Rezoning Transportation Analysis

Petition Number: 2020-161

General Location Identifier: Tax ID 03327114

Date	Description
12-28-2020	First Review (EL)

**THE HUMAN BEAN**  
**LONG CREEK VILLAGE**  
**CHARLOTTE, NC**  
**ZONING EXHIBIT**

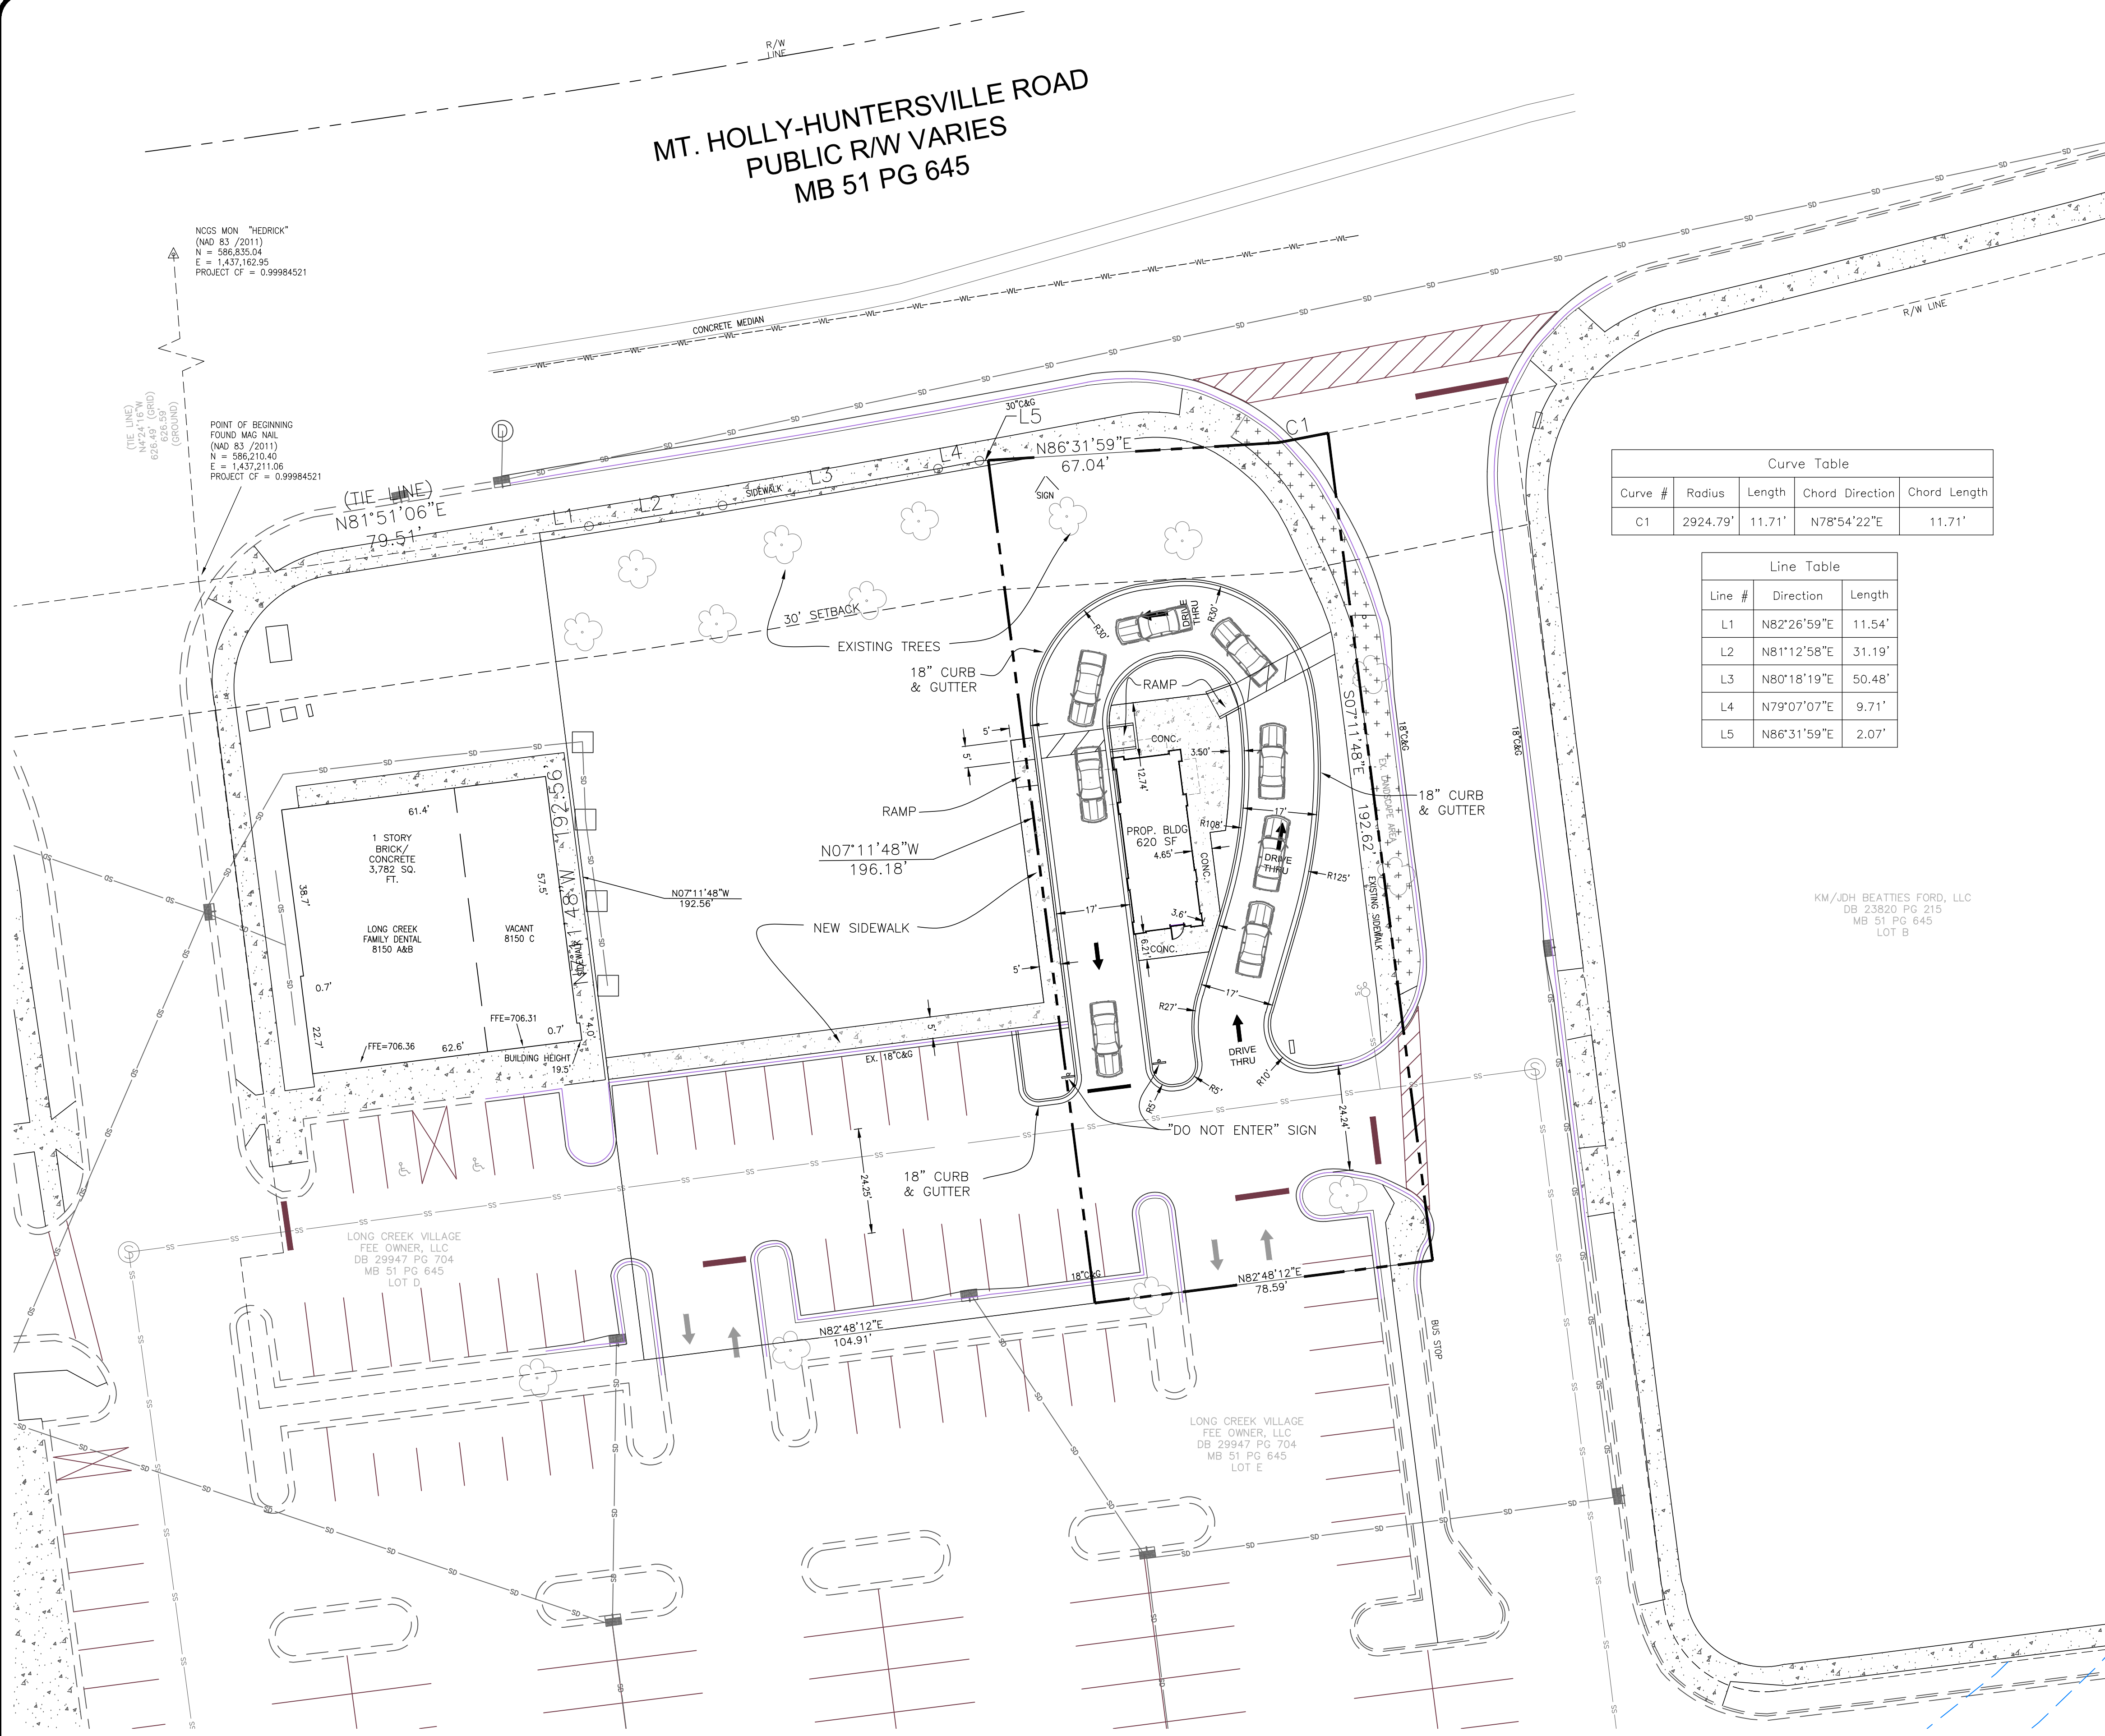
3. Revise site plan and conditional note(s) to commit to dedicate a minimum of 50-feet of public right-of-way from the Mount Holly-Huntersville Road centerline. CDOT requests additional public right-of-way to be dedicated 2-feet behind the existing sidewalk. The site plan shall label and dimension the right-of-way from the road centerline.

4. Revise site plan and conditional note(s) to commit to construct bicycle facilities by installing a 12-foot shared-use path to meet the City Charlotte BIKES Policy.

5. A site plan note(s) specifying dedication and fee simple conveyance of all rights-of-way to the City before the site's first building certificate of occupancy is issued is needed. CDOT requests rights-of-way set at 2' behind back of sidewalk where feasible.

6. A site plan note specifying that all transportation improvements will be approved and constructed before the site's first building certificate of occupancy is issued is needed. The petitioner may phase transportation improvements if said improvements and phasing are explicitly described in site plan notes.
